PLANNING CONSULTATION RESPONSE

Application No	2026/0313
Proposal	Installation of a multifunctional communication Hub including defibrillator and advertisement display. (Advertisement Consent)
Address	Pavement opposite 36 - 38 Eldon Street, Barnsley
Date of Consultation Reply	18/05/26
Consultee	Highways DC

SITE PLAN & IMAGES

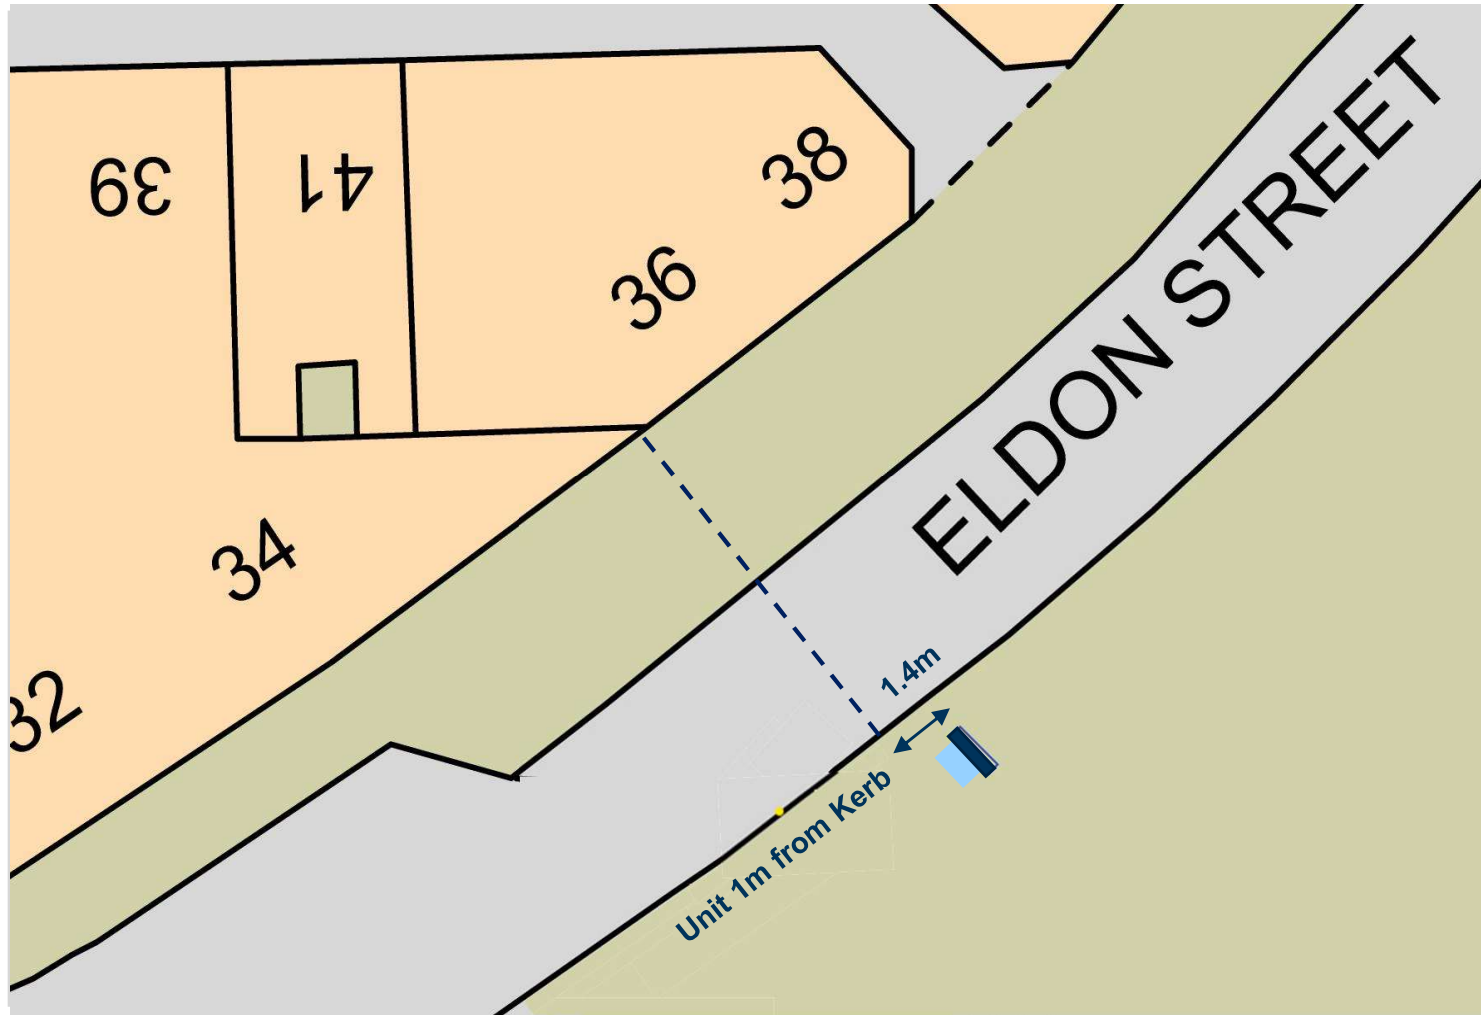
There have been multiple applications previously made by BT to replace existing telephone boxes with communications hubs, and the view has been taken that each of these was a less onerous obstruction than the existing telephone box given the dimensions of each. This proposal is for a brand-new facility in the busy town centre, and HDC officers would not wish to see a proliferation of these hubs throughout the town and beyond, adding to street clutter and causing obstruction on busy pedestrian routes.

As such, HDC would raise objection to the scheme on the grounds that the proposal increases unnecessary street clutter within the town centre.
